PERSIMMON HOMES THAMES VALLEY
NORTH LITTLEHAMPTON
FITZALAN LINK S278 WORKS
LITTLEHAMPTON, WEST SUSSEX

STAGE 1 - ROAD SAFETY AUDIT
ADDENDUM

Project Code:	S/PHFITZ.1.1AD.6a
Prepared by:	Martyn Parr
Approved by:	John Reid
Issue Date:	August 2017
Status:	FINAL

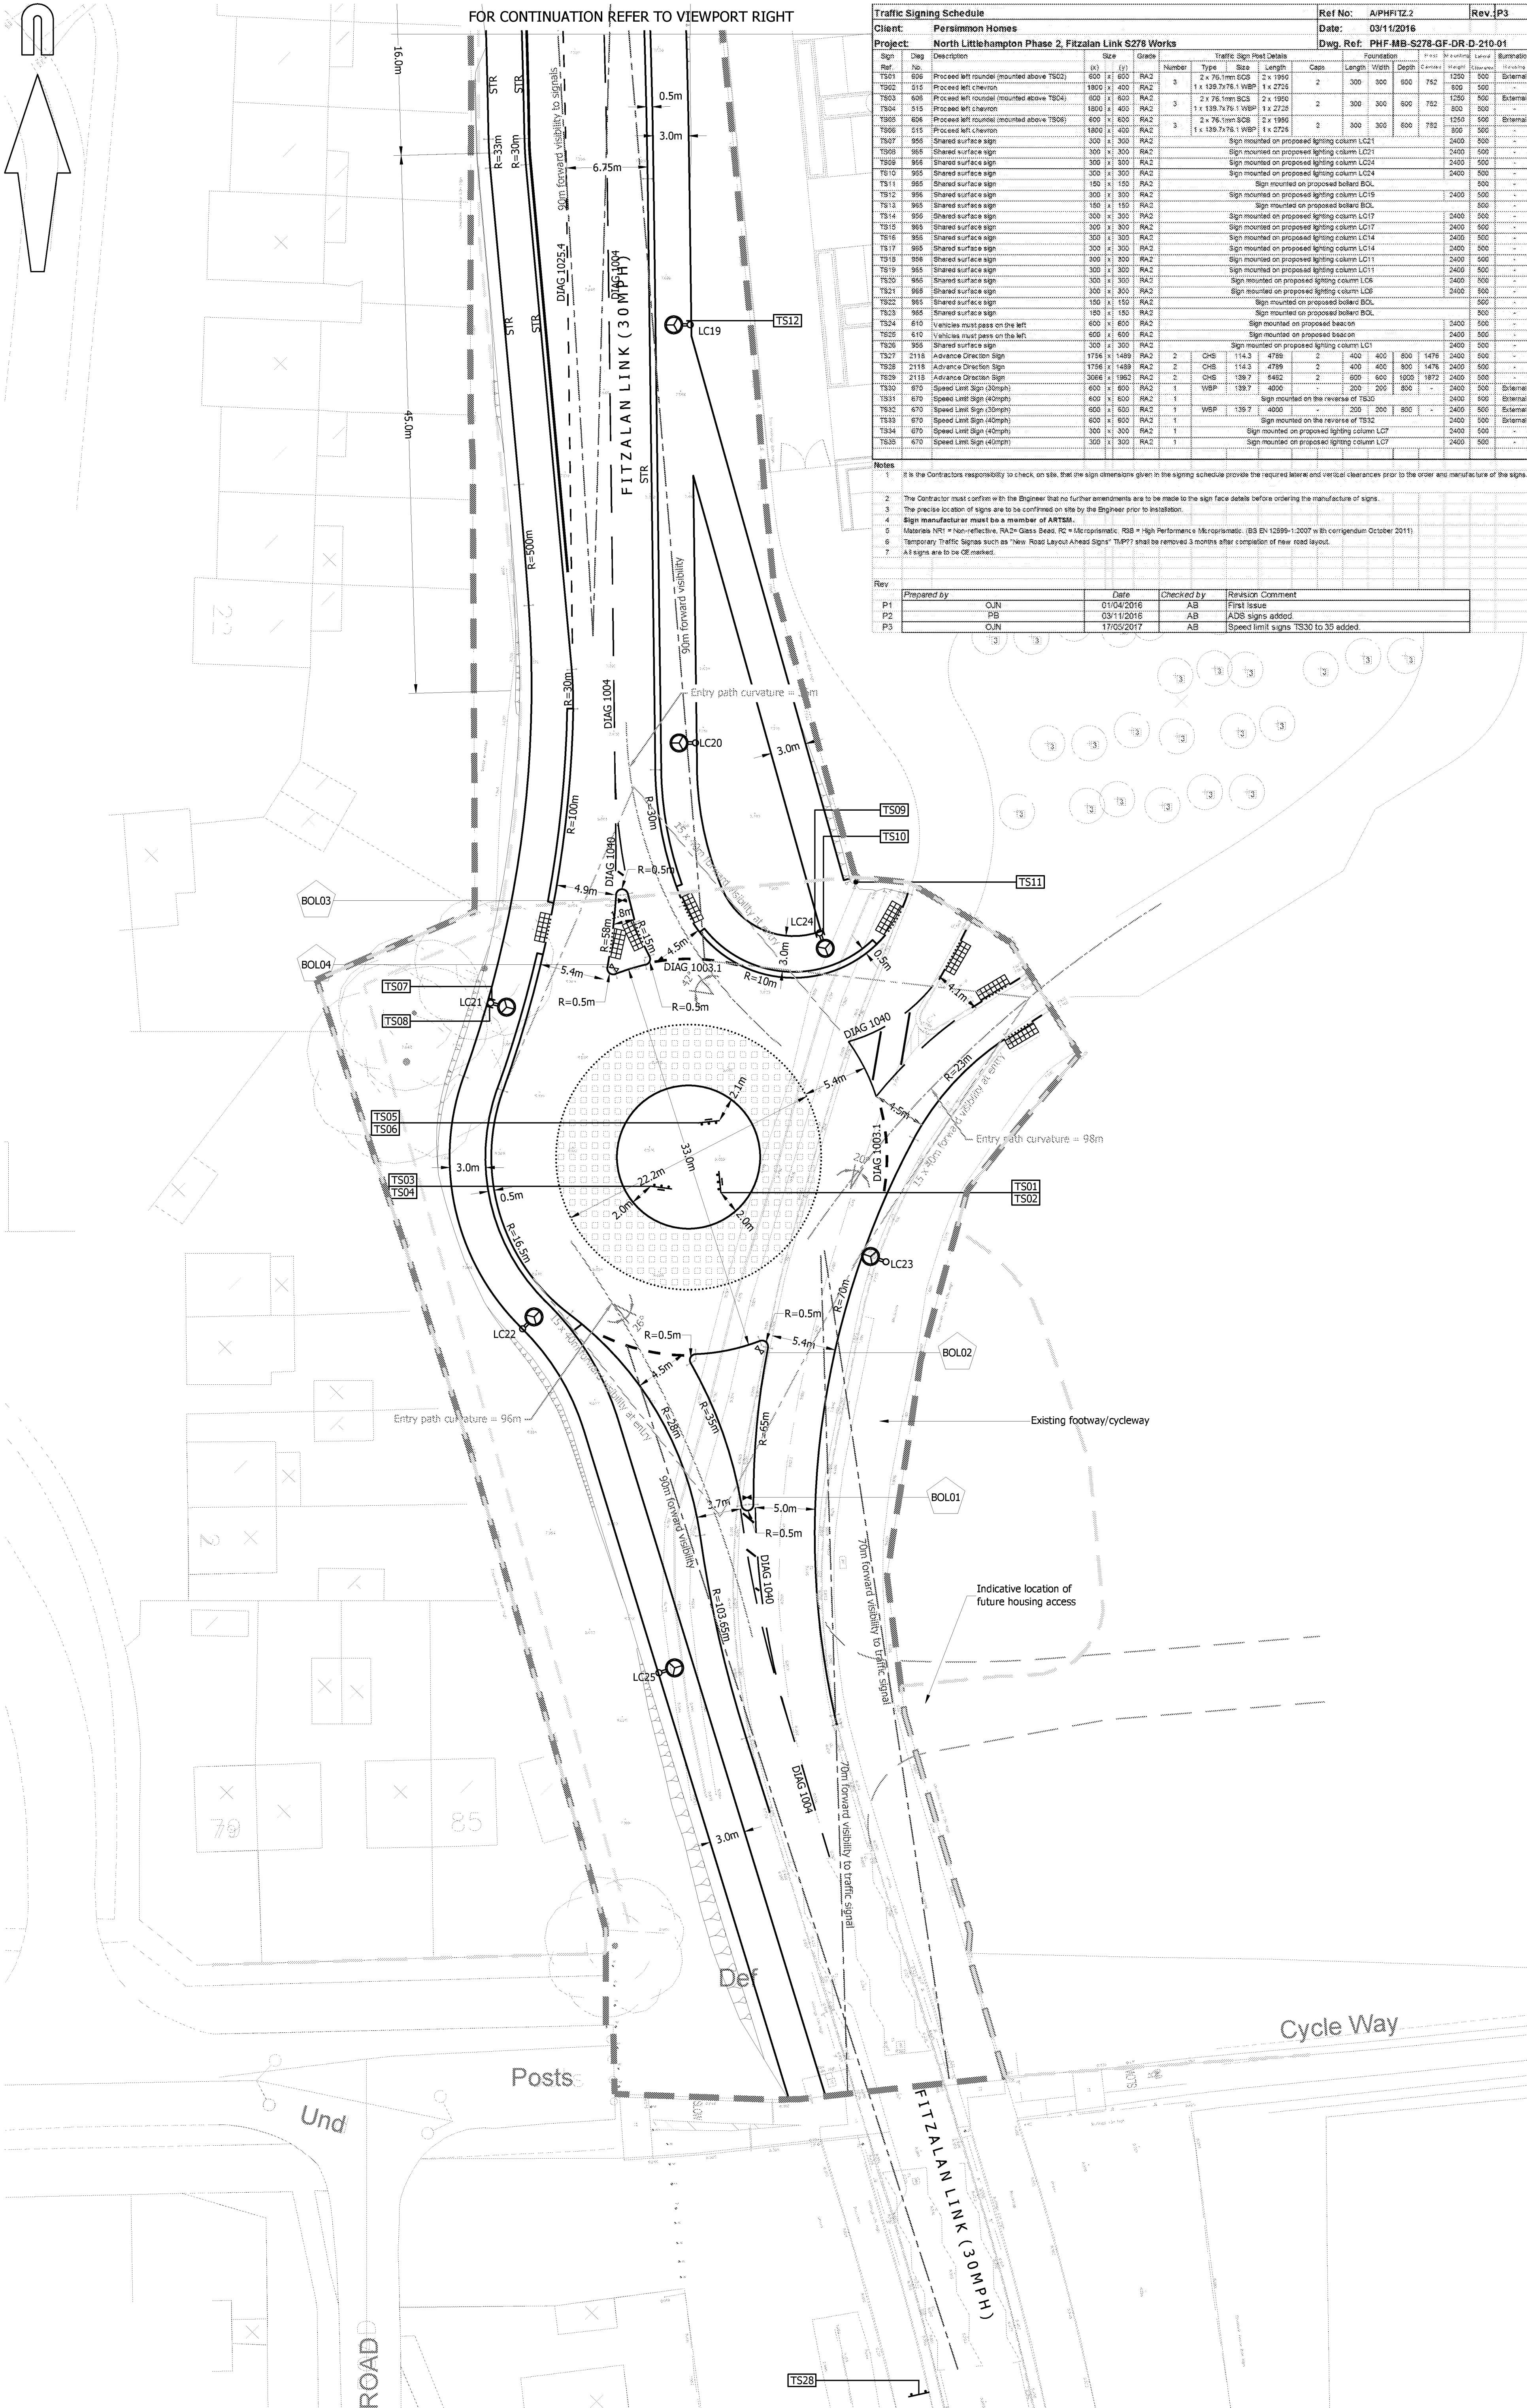
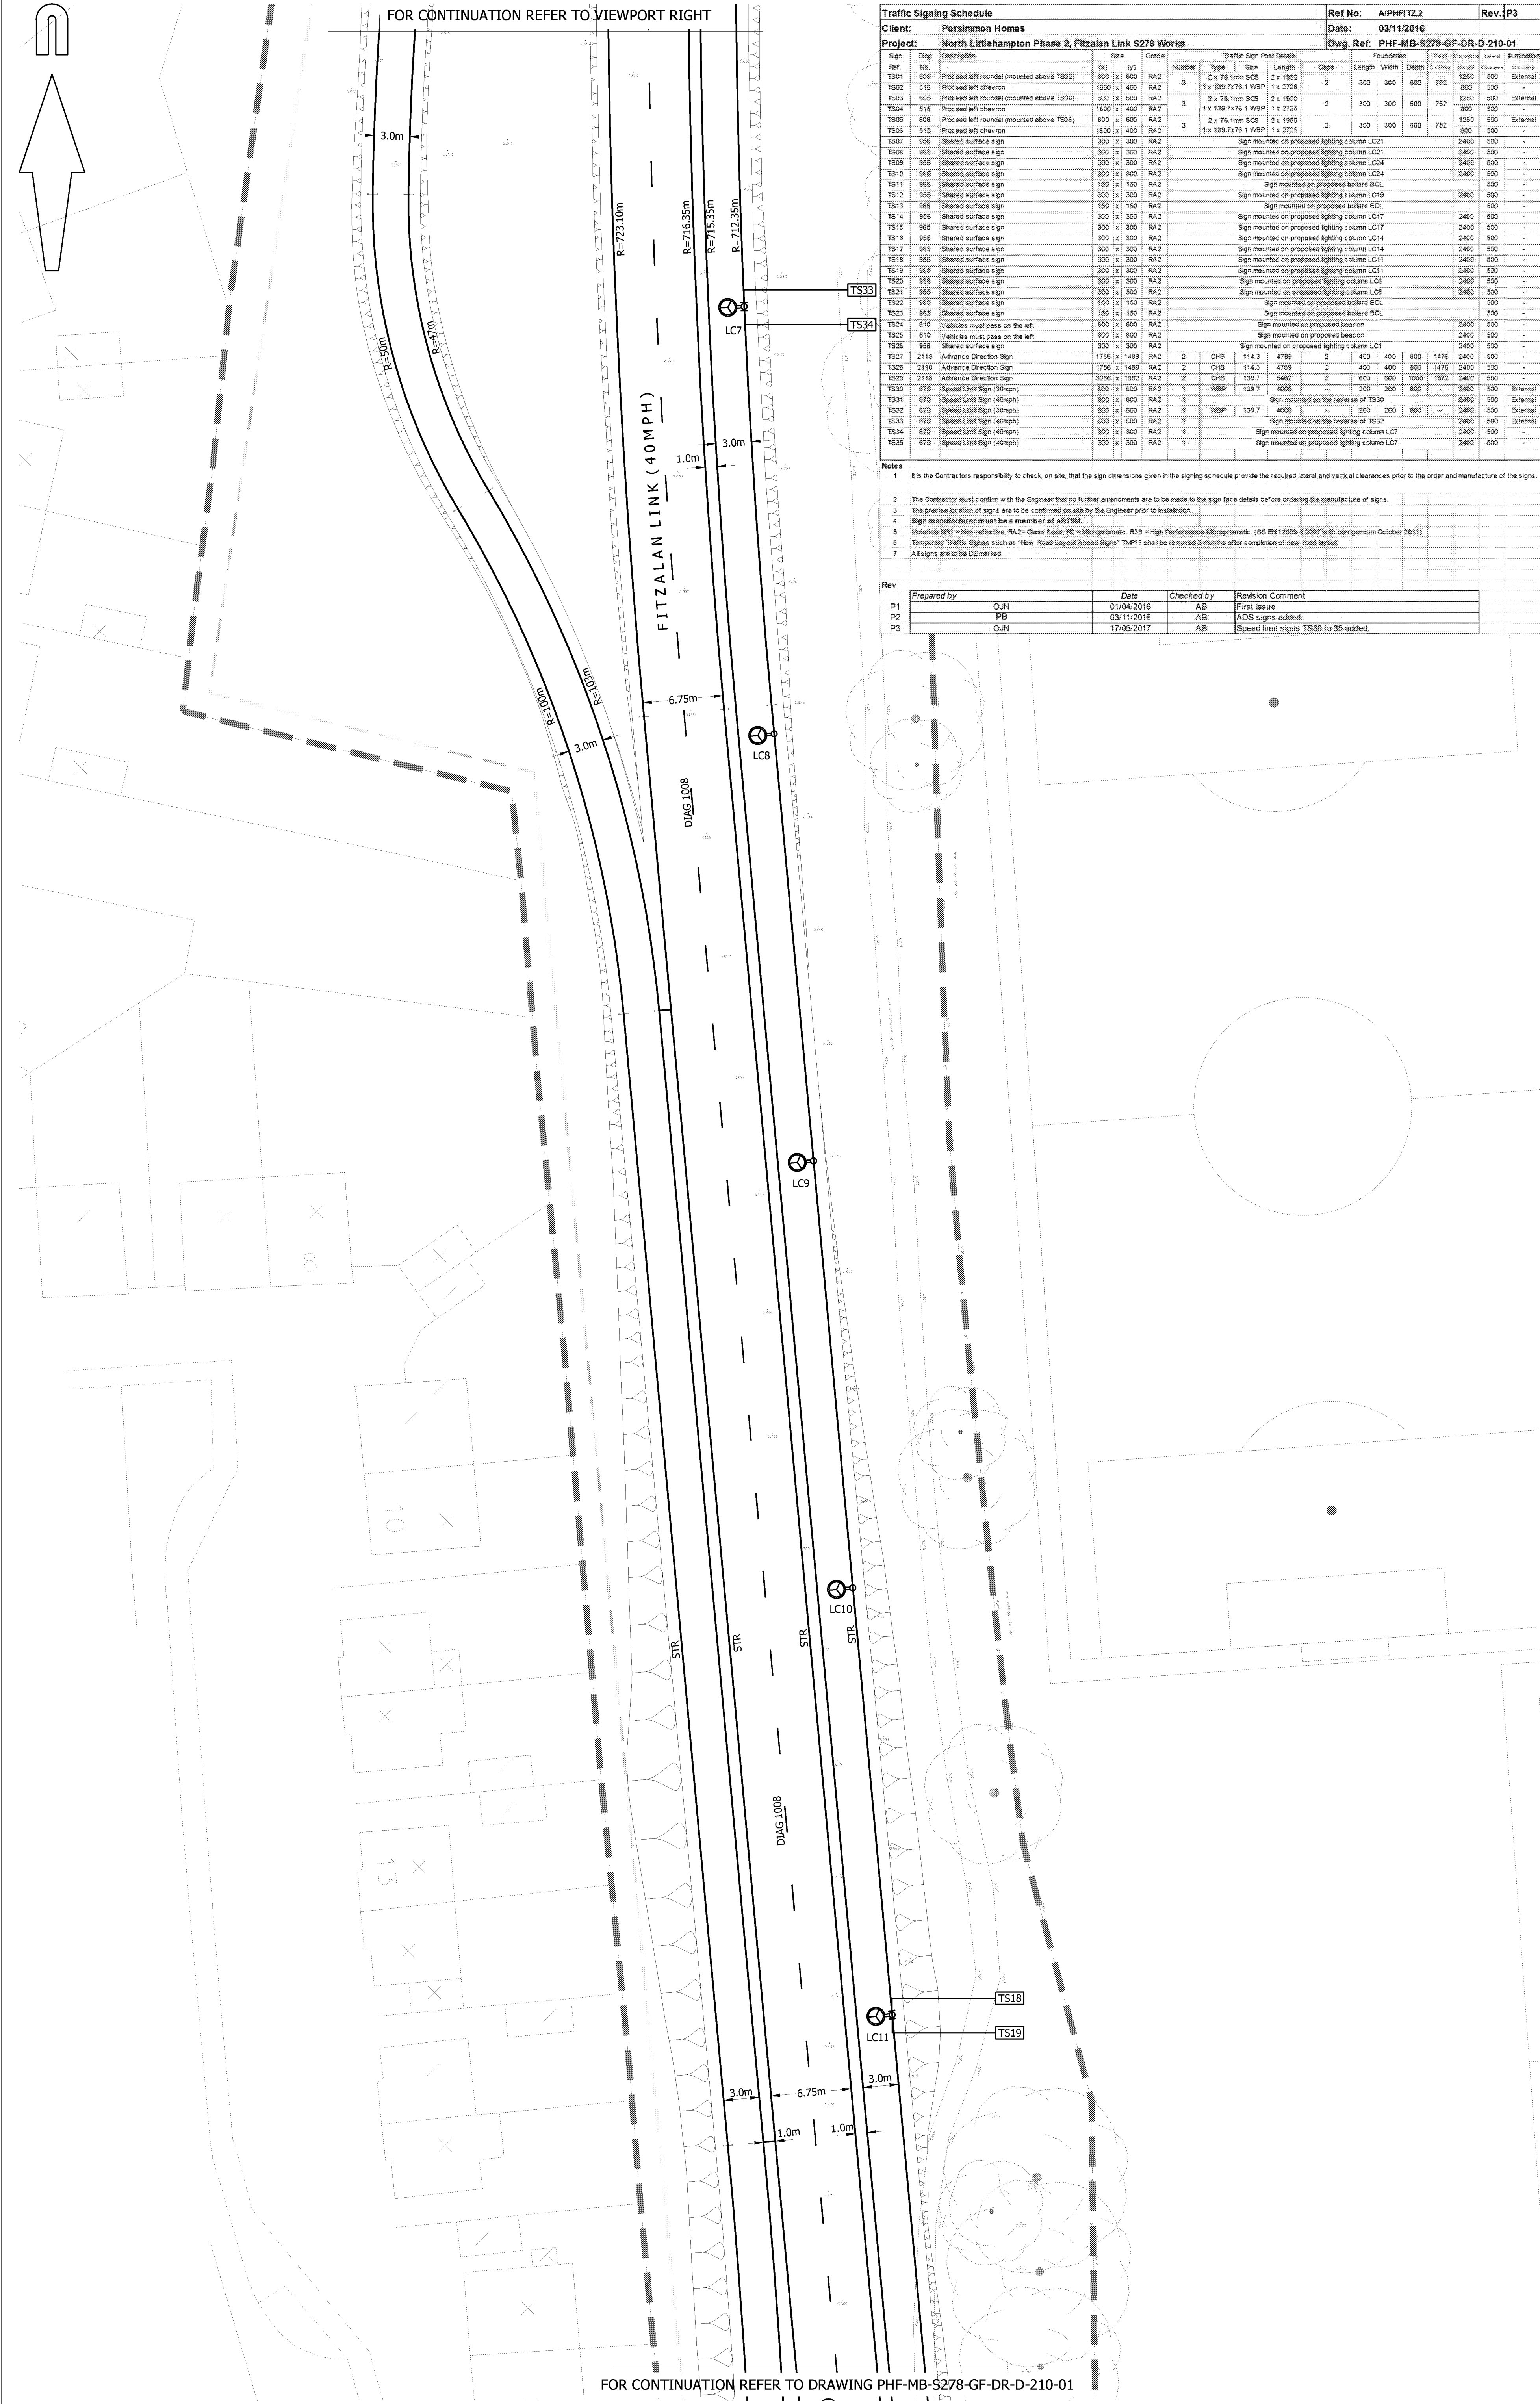
Location: Proposed roundabout junction

Summary: Junction 'see through'

Details of chevron signing on the roundabout central island have not been submitted at this stage. It will be important that a "see through" effect is not created which could result in drivers overshooting the circulatory carriageway and central island.

Ensure "see through" is prevented by suitable provision and location of chevron signs and / or other features.

Location: Southbound approach to proposed roundabout

Summary: Approach speeds – Pedestrian & vehicle collisions

Details of anti-skid surfacing treatment have not been provided, providing anti-skid surface treatment would help prevent loss of control, side on or rear end collisions or collisions with pedestrians / cyclists using the toucan crossing who may enter the carriageway in front of a moving vehicle.

For southbound drivers, the roundabout junction is located at the end of a straight section of road that is subject to a 40-mph speed limit. Whilst the change in speed restriction is located some distance from the roundabout, there is concern that drivers will not identify the junction early enough and approach too fast to permit controlled braking, resulting in the risk of junction overshoots or tail-end collisions.

Provide anti-skid surface treatment in accordance with design standards on the southbound approach to the roundabout and both approaches to the toucan crossing.

Location: Fitzalan Link Road (please refer to reference point 2.5 in Appendix B)

Summary: Incorrect roundels provided on traffic island

The traffic bollards to be provided on the proposed traffic island will have plain face roundels, indicating that vehicles can pass either side of the island. This could result in vehicles passing the island on the offside resulting in a head on type collision with an oncoming vehicle.

Ensure 'keep left' roundels are provided on the proposed traffic bollards.
